Title
SITE PLANS

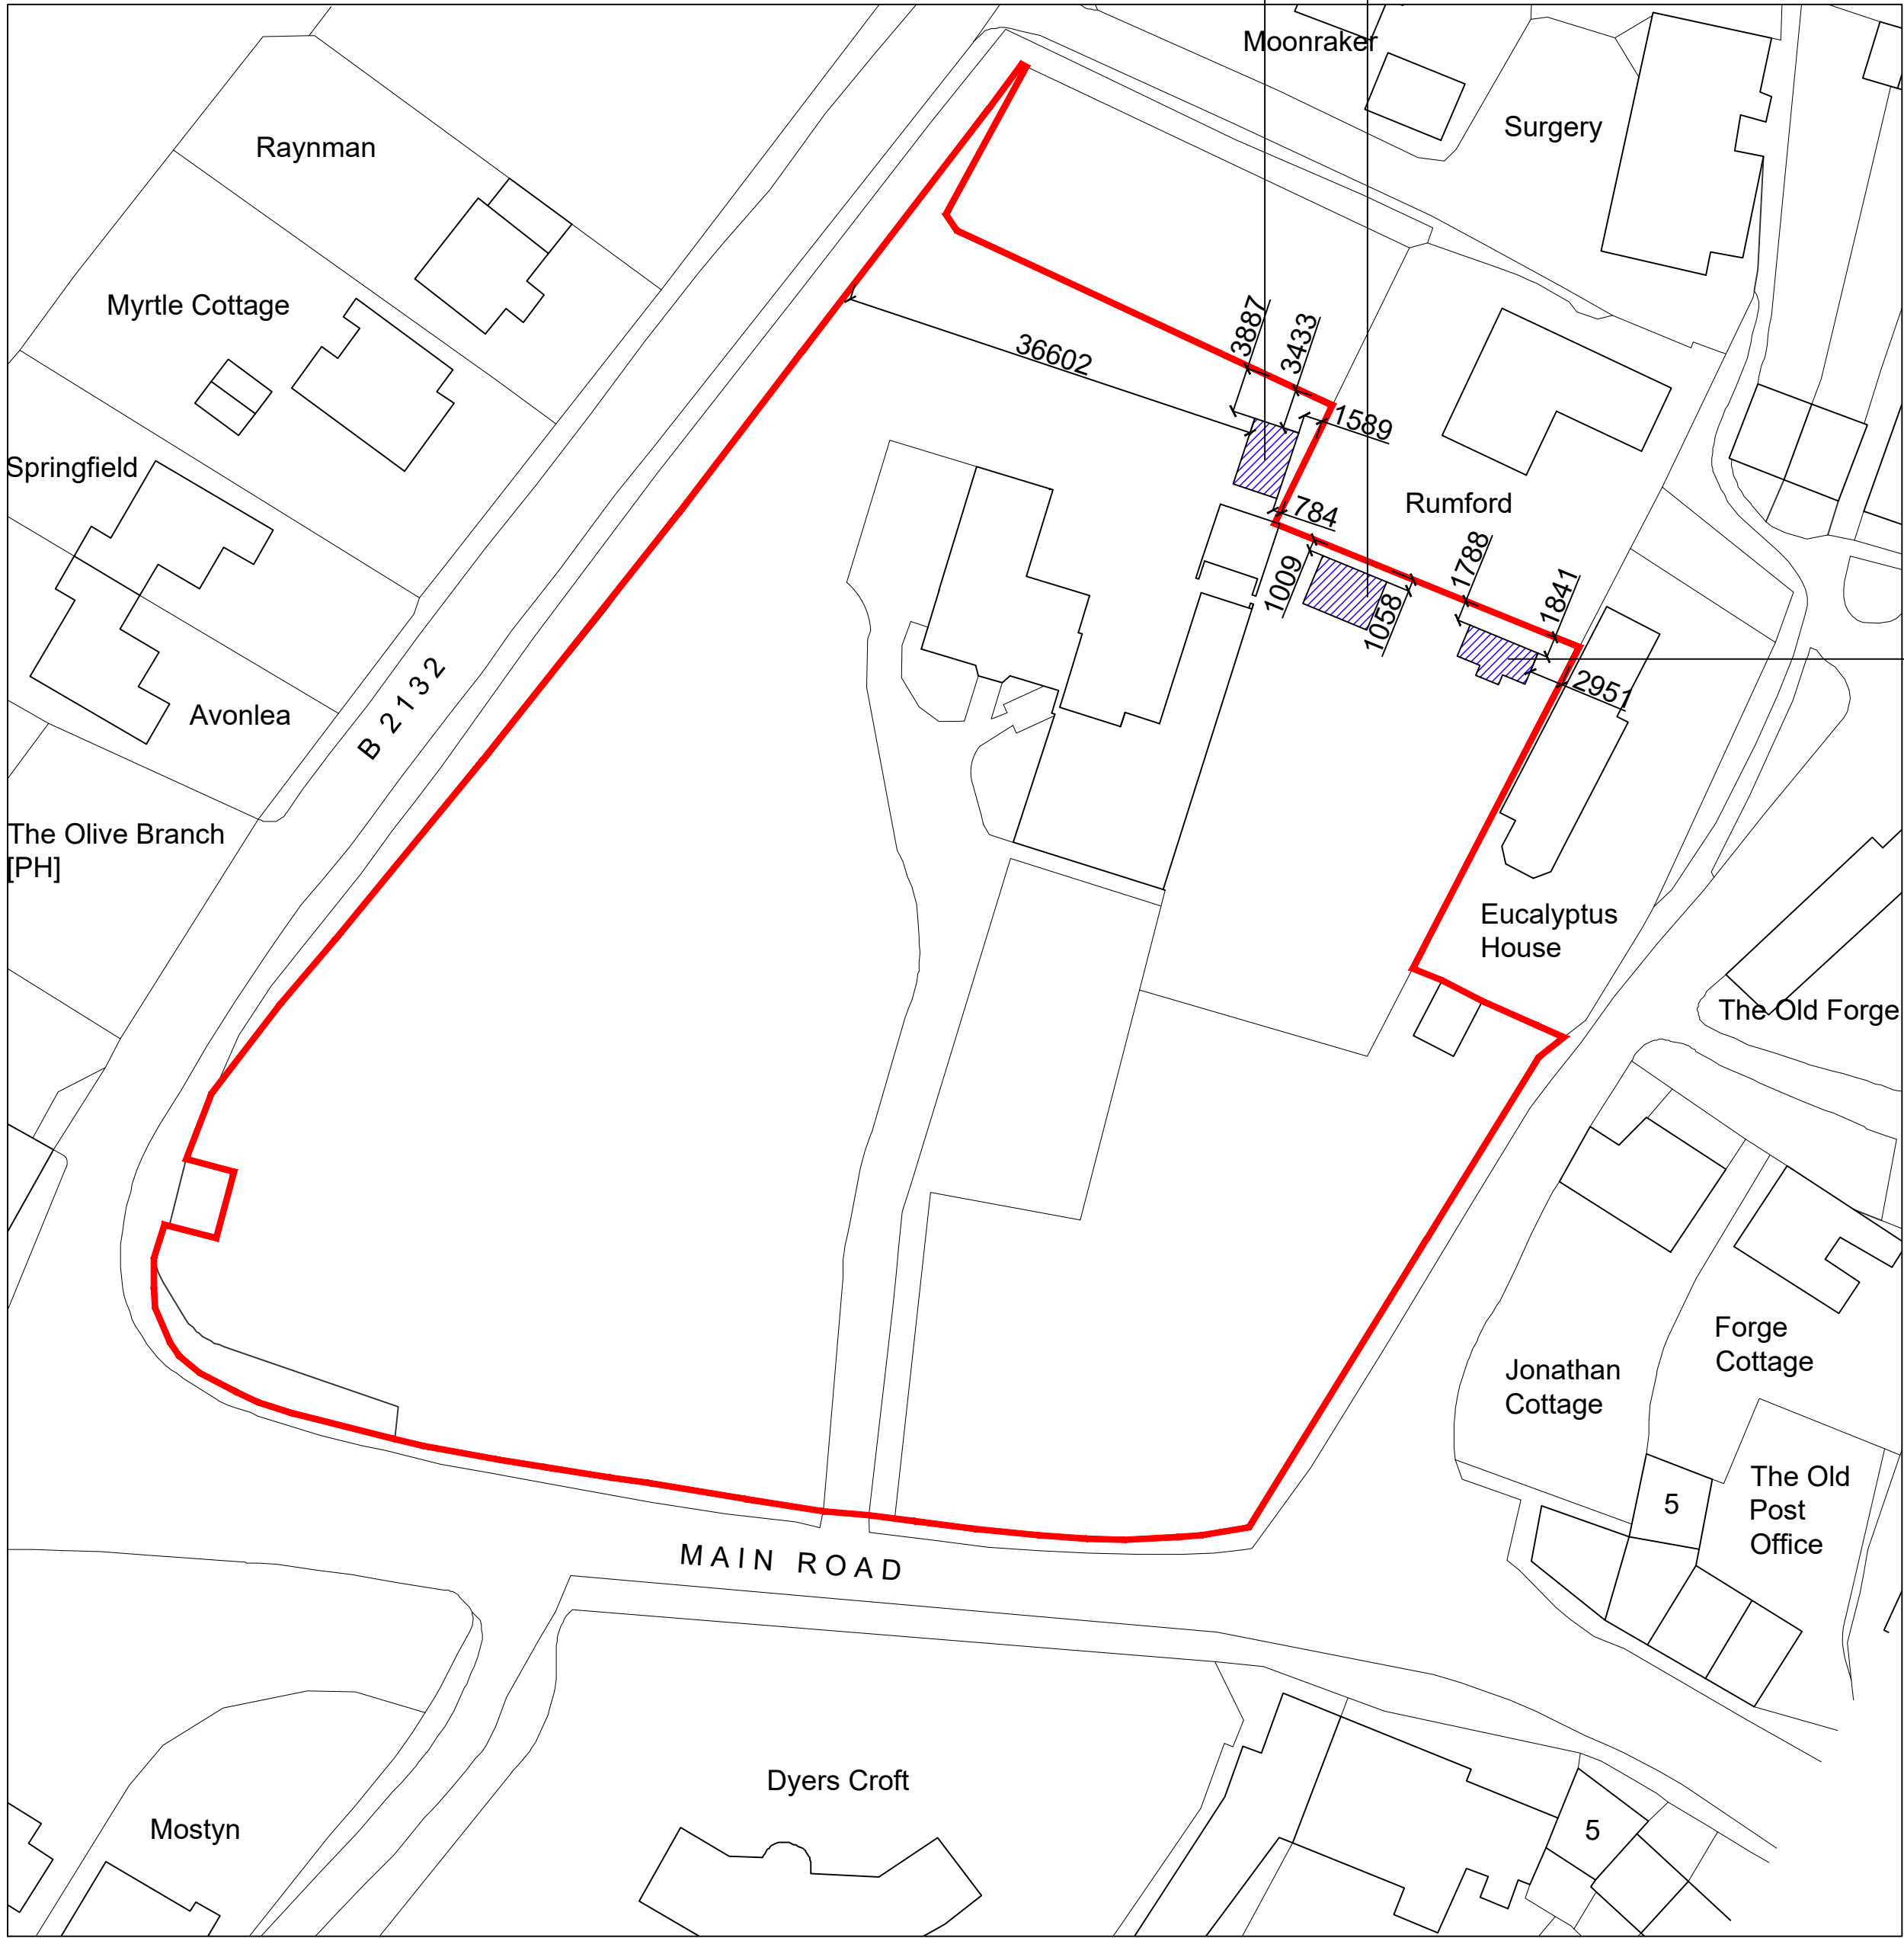
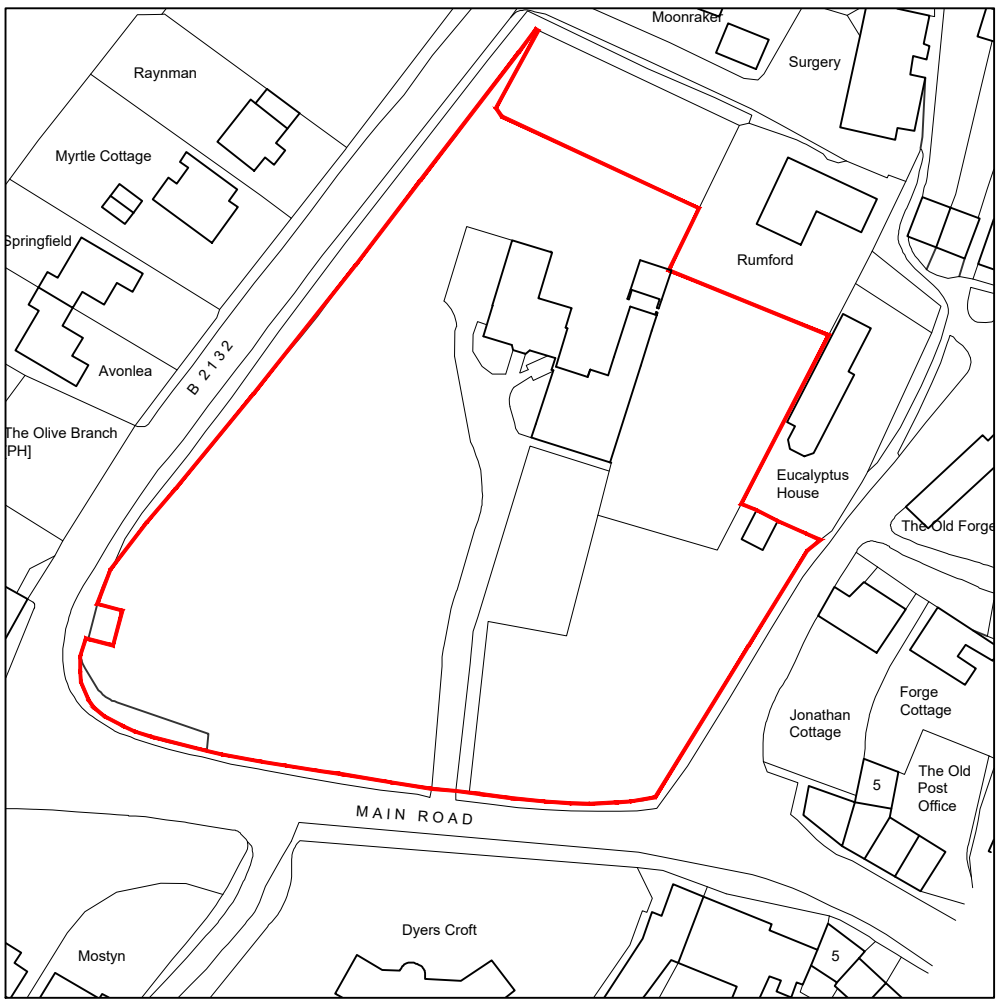
However, could you please also add the dimension from the gym to the other site boundary?

I have now amended the site plan as requested.
